# Rezoning Transportation Analysis

Petition Number: 2020-023

Date	Description
03-20-20	First Review
05-27-20	Second Review
06-24-2020	Third Review (KP)

RZ-1.0

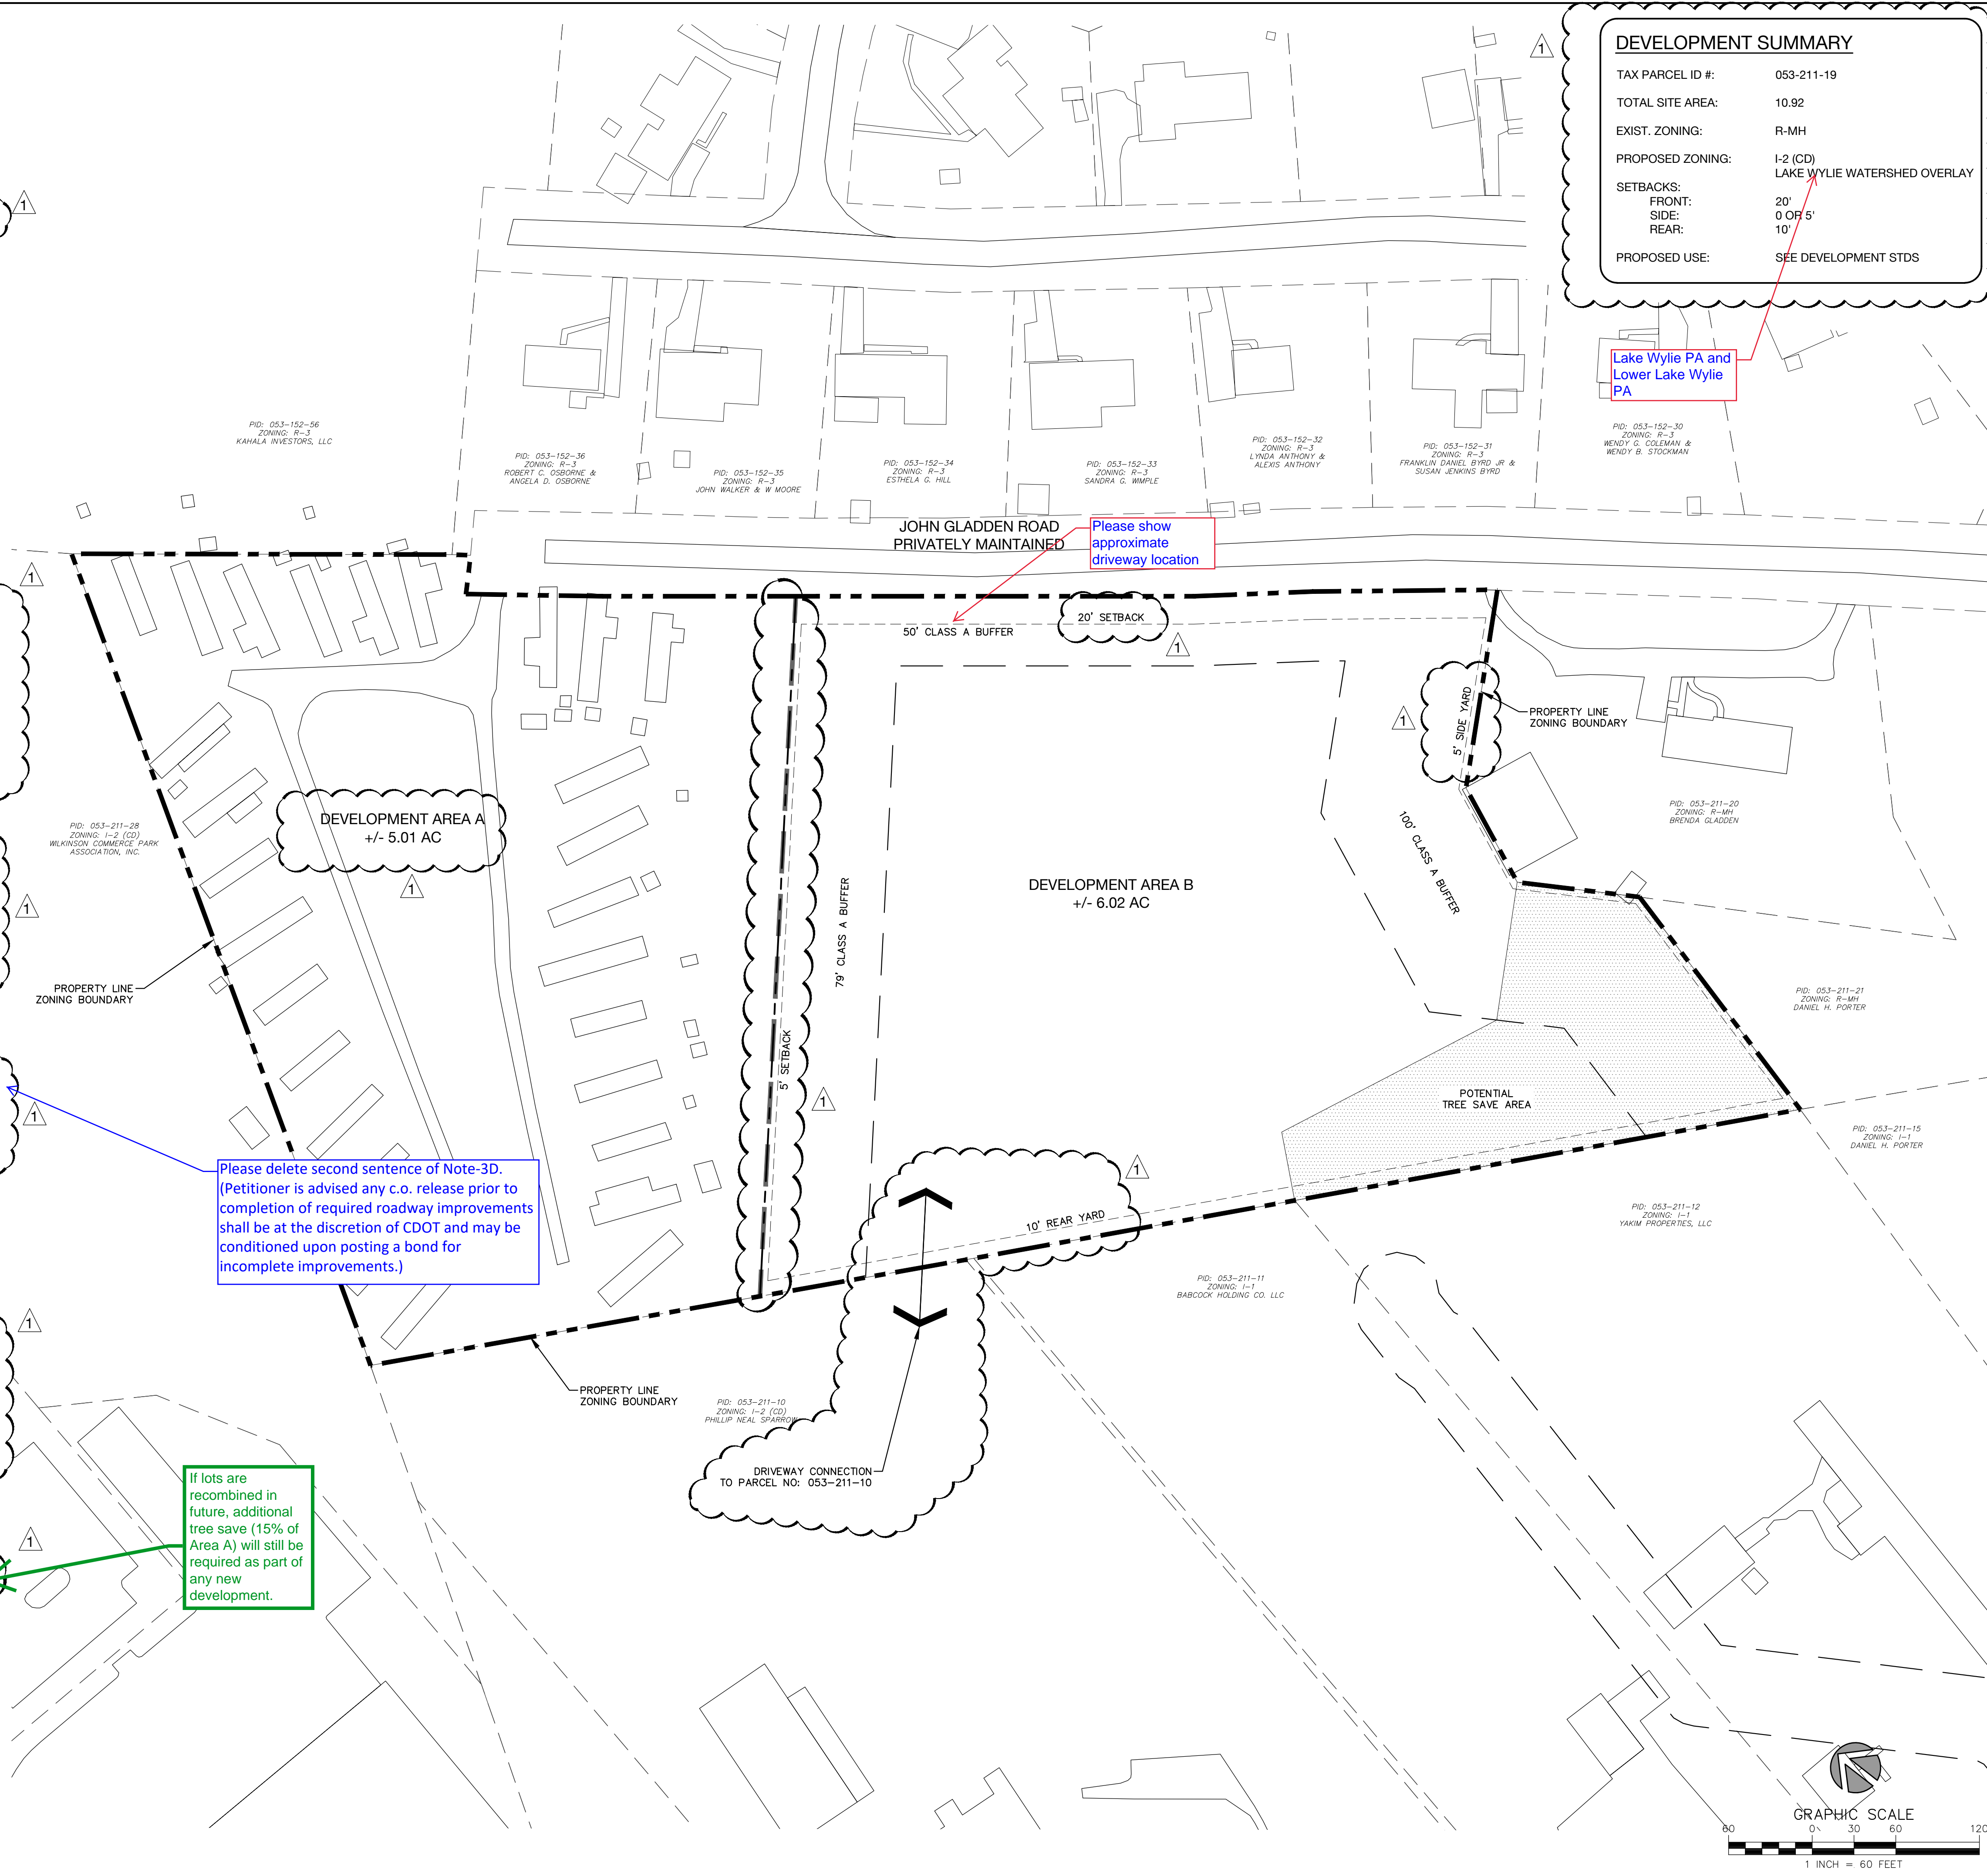
11. **Outstanding - Comment on revised site plan (05-05-2020)** The petitioner should revise the site plan and conditional notes, in reference to Sections 3.A. and 3.B., to establish and record a cross access easement across Tax Parcel Nos. 053-211-07 and 053-211-10 to Wilkinson Boulevard. **Access agreement for all three parcels in the event that one or more parcel(s) is sold to another individual/entity for access to be maintained to Wilkinson.**

RZ-1.0

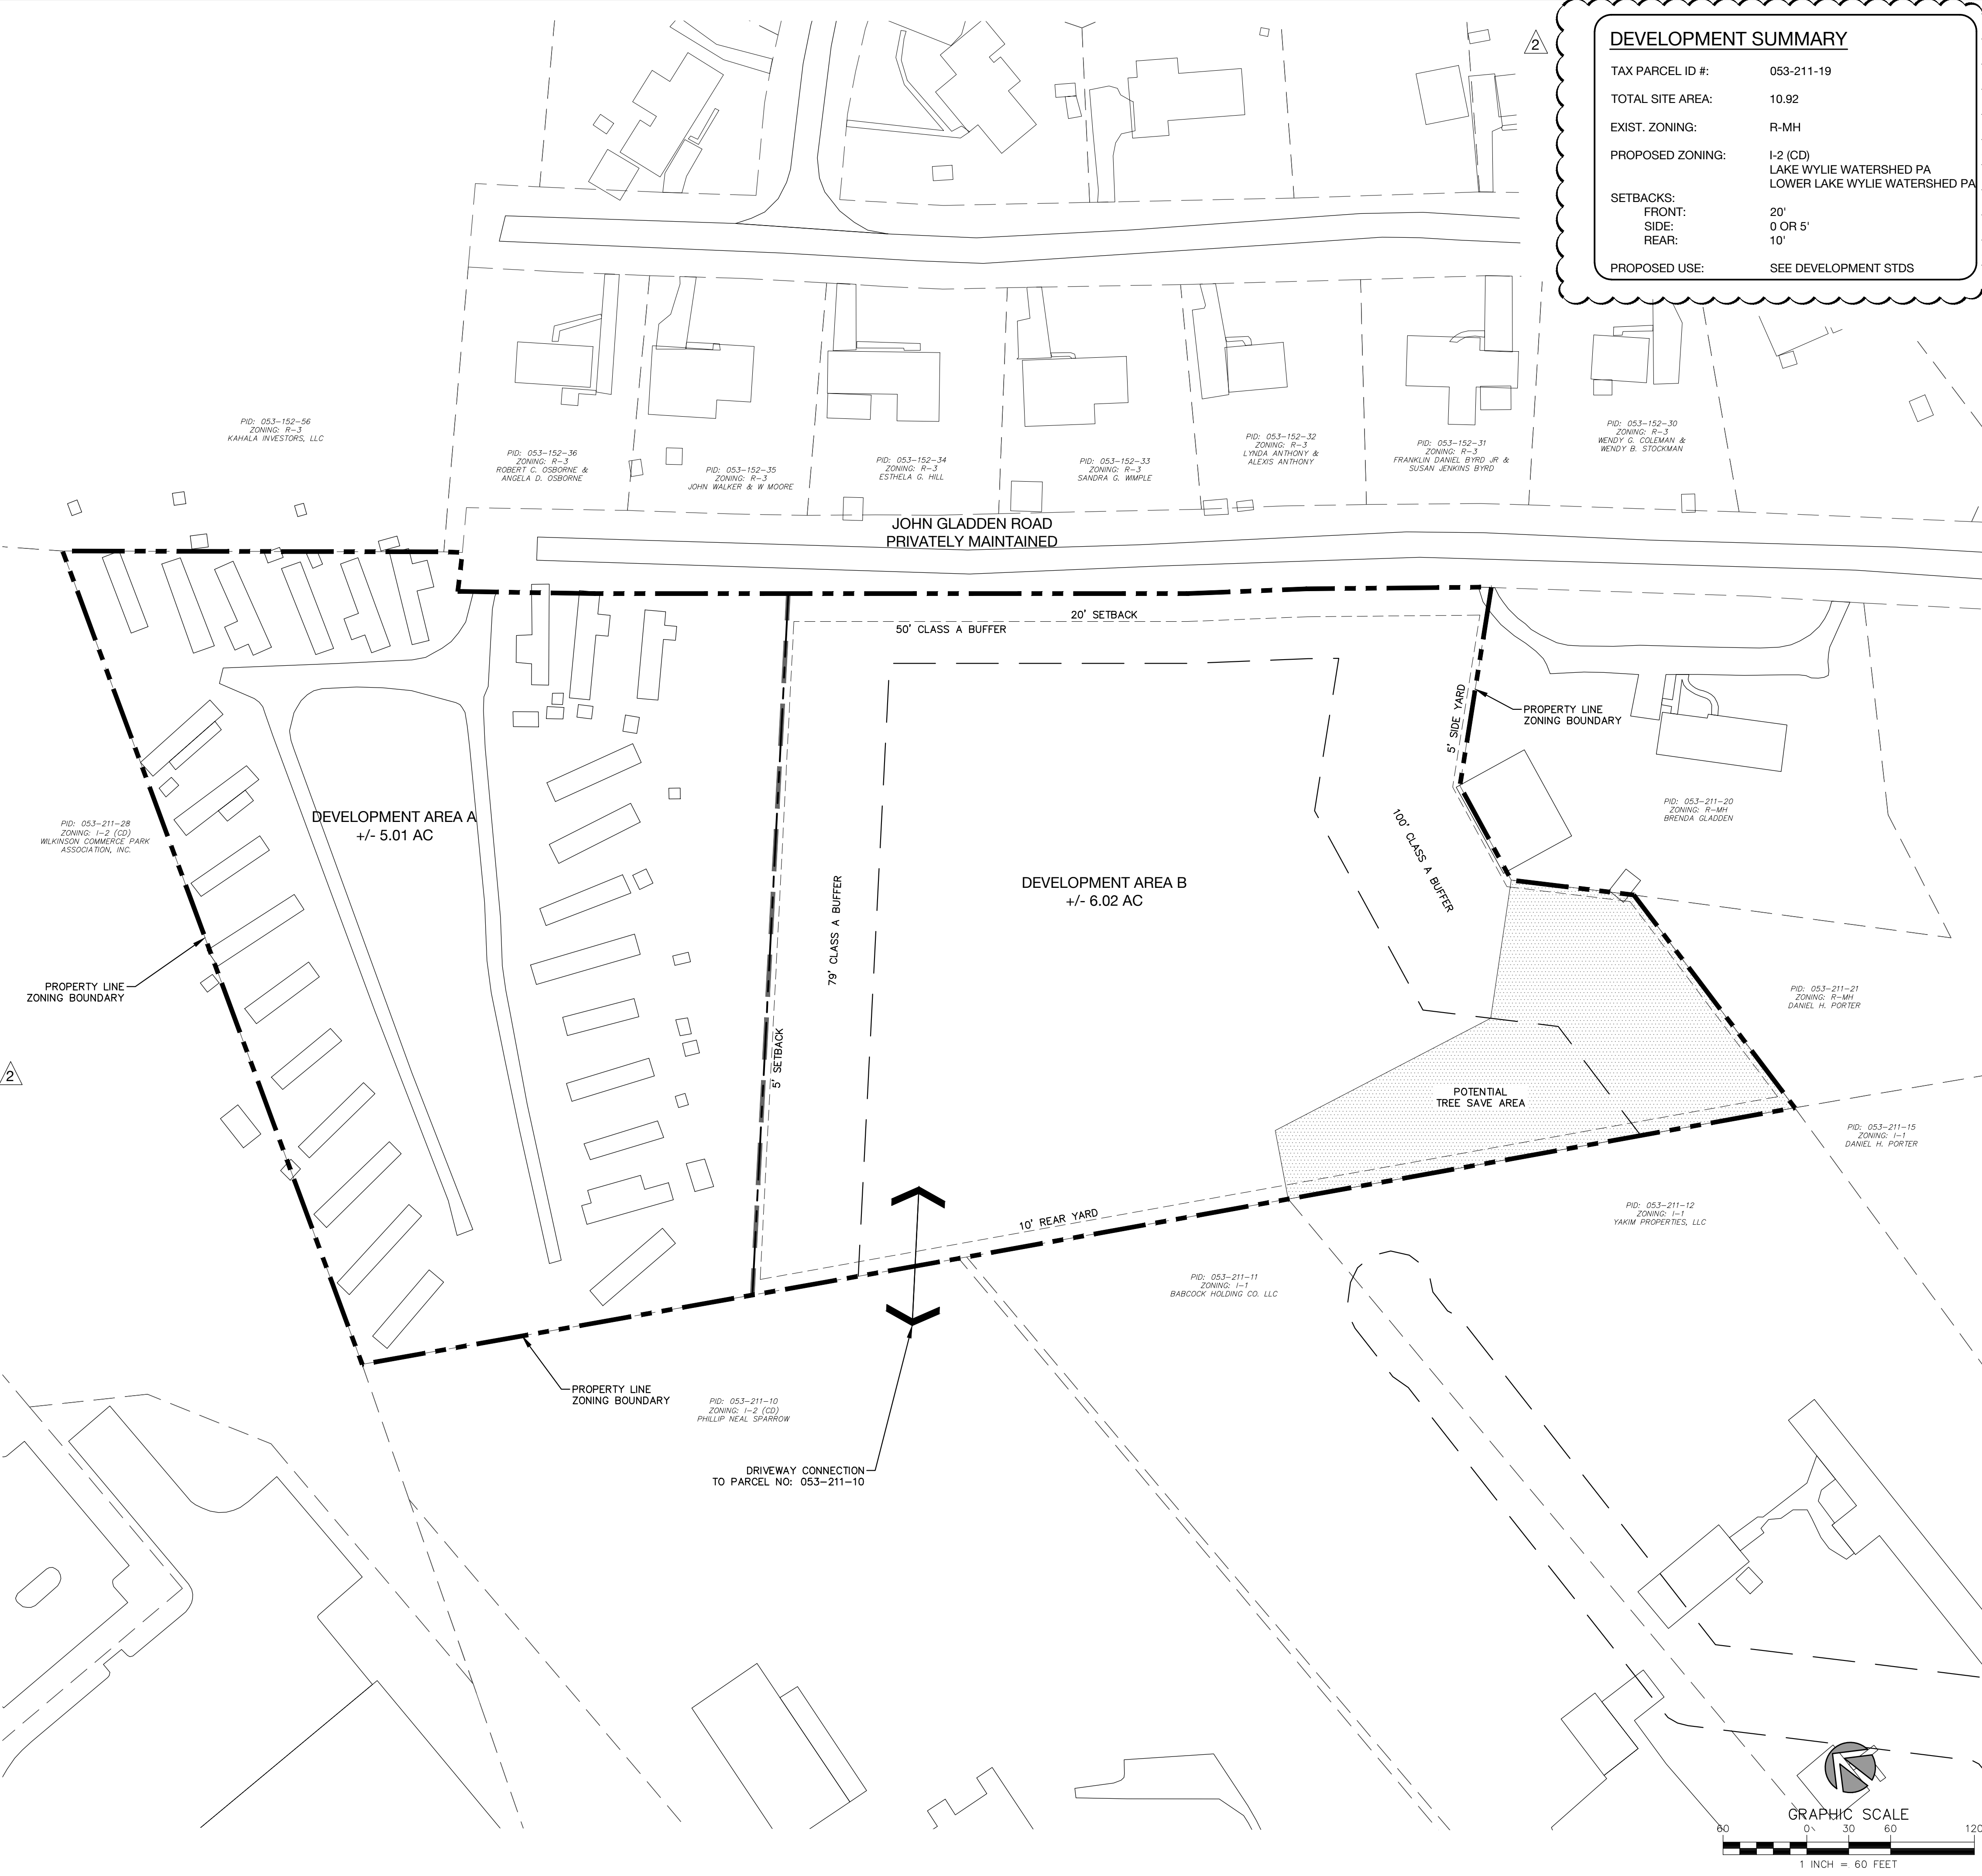
6. If realigning John Gladden Road is necessary, the petitioner should revise the site plan and conditional note(s) to commit to re-striping a left turn lane on Sam Wilson Road, in coordination with CDOT and NCDOT.

7. The petitioner should revise the site plan to remove the "city maintained" label under John Gladden Road. This road is not maintained by NCDOT and may either be privately maintained or unmaintained.
